Ribble Valley Borough Council
By email

Your ref 3/2025/0870
Our ref DC/25/2866
Date 24-NOV-25

Location: 18 Accrington Road (Former Whalley Motor Services) Whalley BB7 9TD
Proposal: Proposed demolition of former motor services building and construction of new office building.

**7261 -003A**

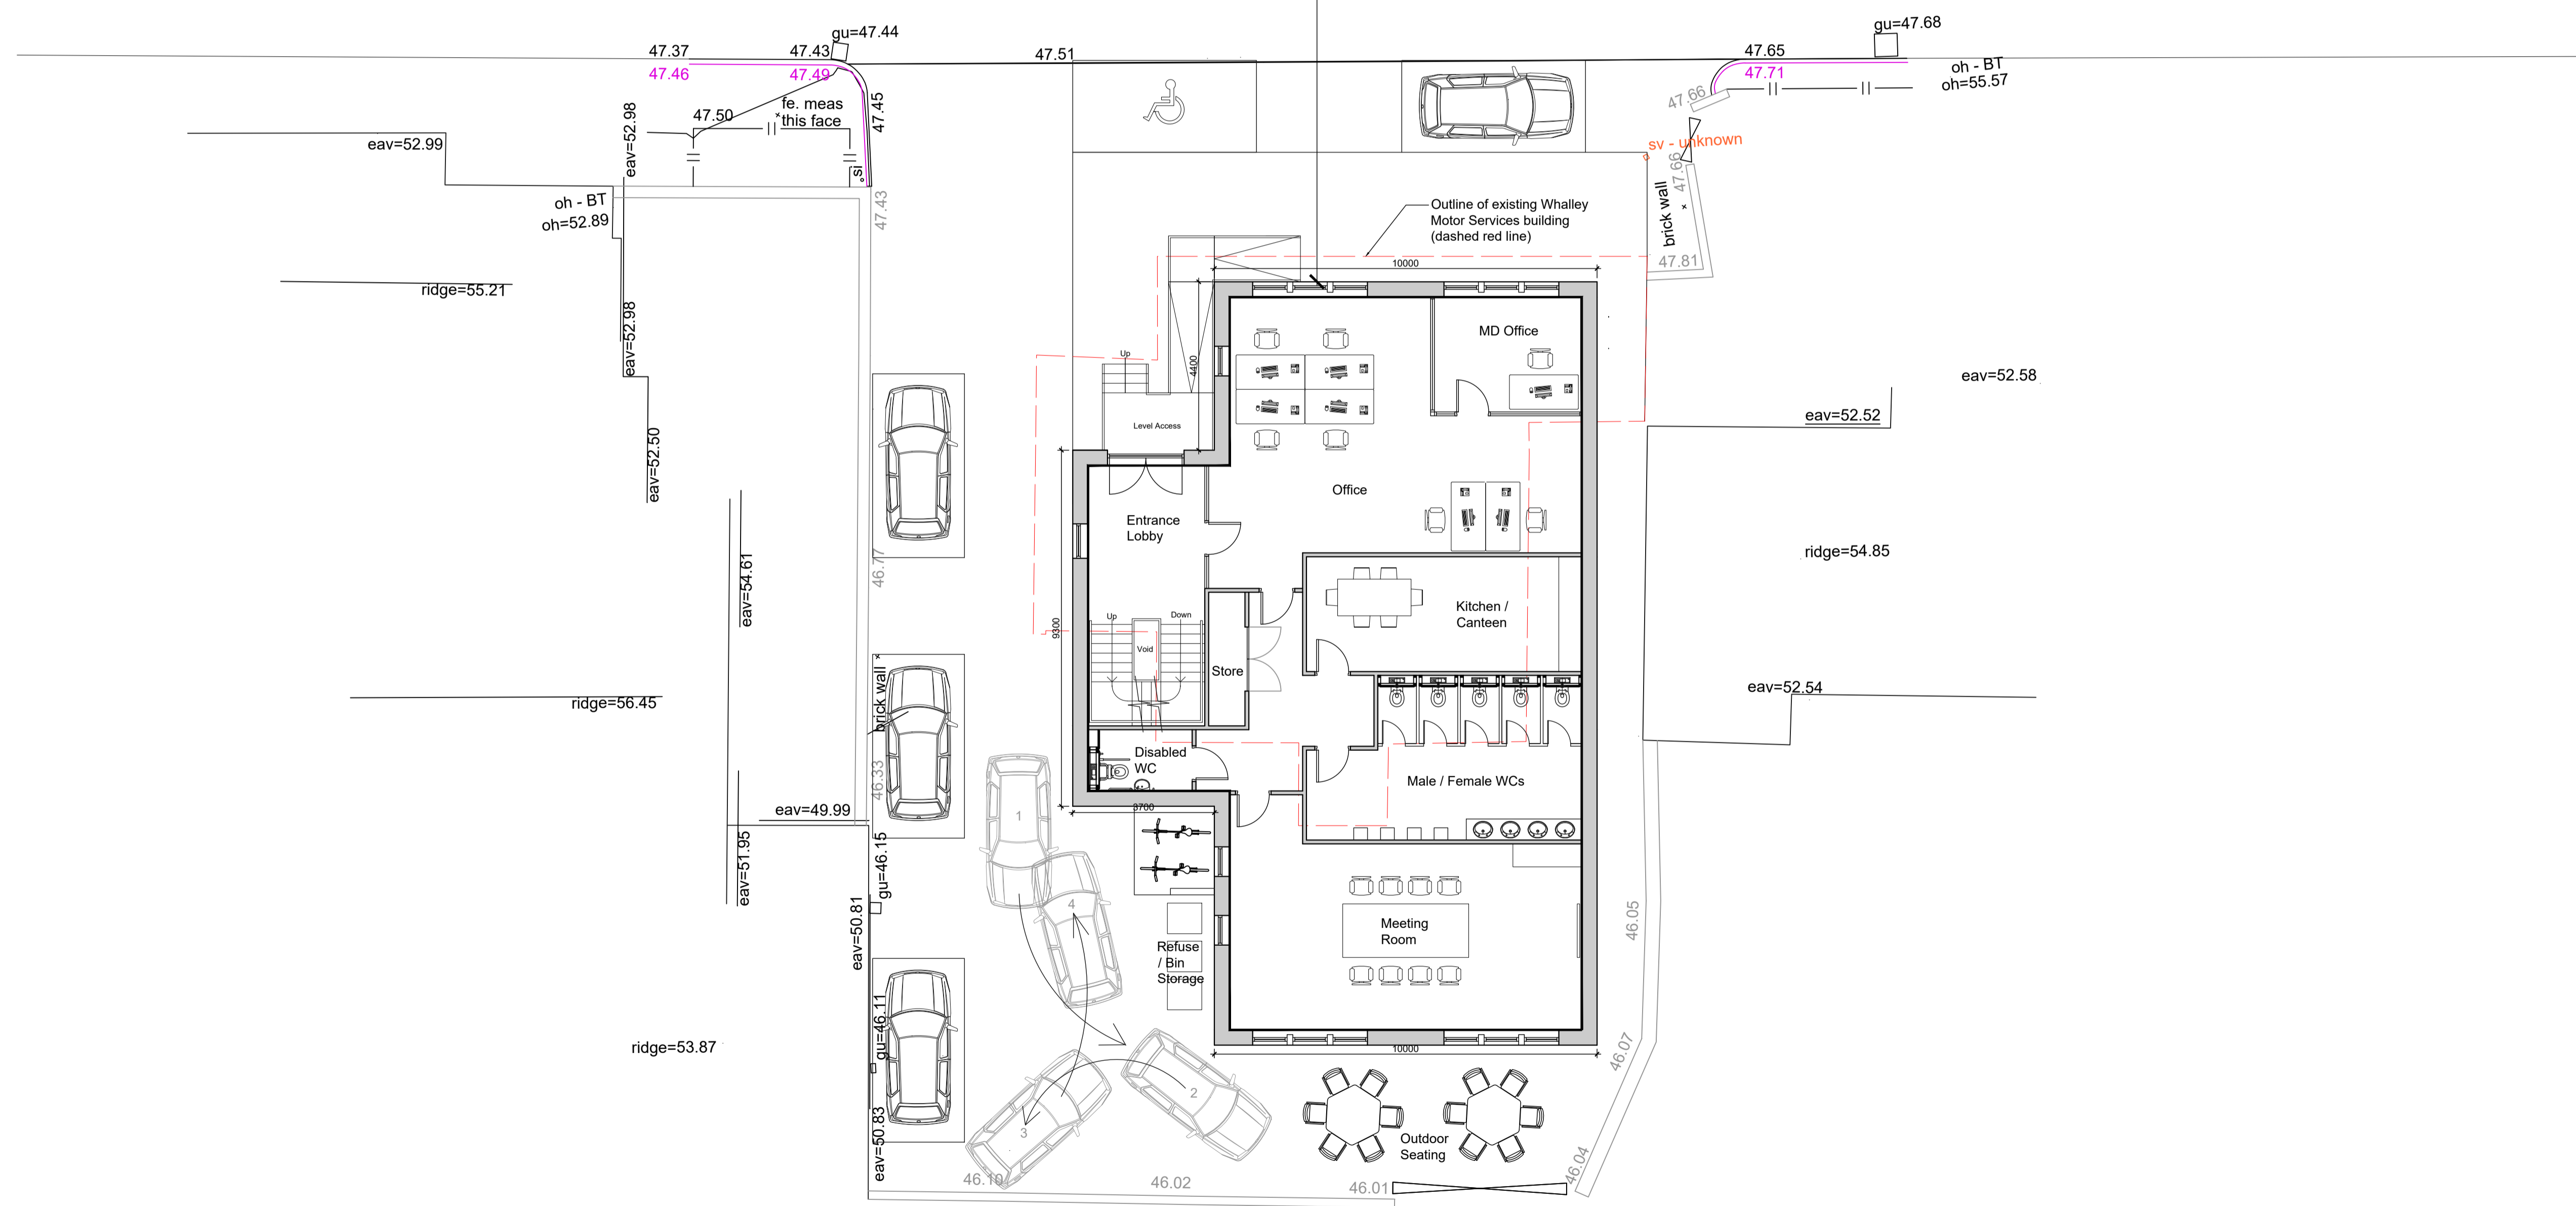
Following our review of the submitted drainage documents; Flood Risk Assessment, prepared by PSA Design Ltd, Ref: D4737-R-01, Dated October 2025, (DELETE AS APPROPRIATE) the drainage proposals are not acceptable to United Utilities. This is because we have not seen robust evidence that that the drainage hierarchy has been thoroughly investigated and the proposals are not in line with the National Standards for Sustainable Drainage Systems (2025). Please note that the finished floor levels appear to be lower than all adjacent manholes, please can this be reviewed?

Prior to the commencement of development, details of a sustainable surface water drainage scheme and a foul water drainage scheme shall be submitted to and approved in writing by the Local Planning Authority. The drainage schemes must include:

- (i) An investigation of the hierarchy of drainage options in the National Standards for Sustainable Drainage Systems (or any subsequent amendment thereof). This investigation shall include evidence of an assessment of ground conditions and the potential for infiltration of surface water;***
- (ii) A restricted rate of discharge of surface water agreed with the local planning authority (if it is agreed that infiltration is discounted by the investigations);***
- (iii) Levels of the proposed drainage systems including proposed ground and finished floor levels in AOD;***
- (iv) Incorporate mitigation measures to manage the risk of sewer surcharge where applicable; and***
- (v) Foul and surface water shall drain on separate systems.***
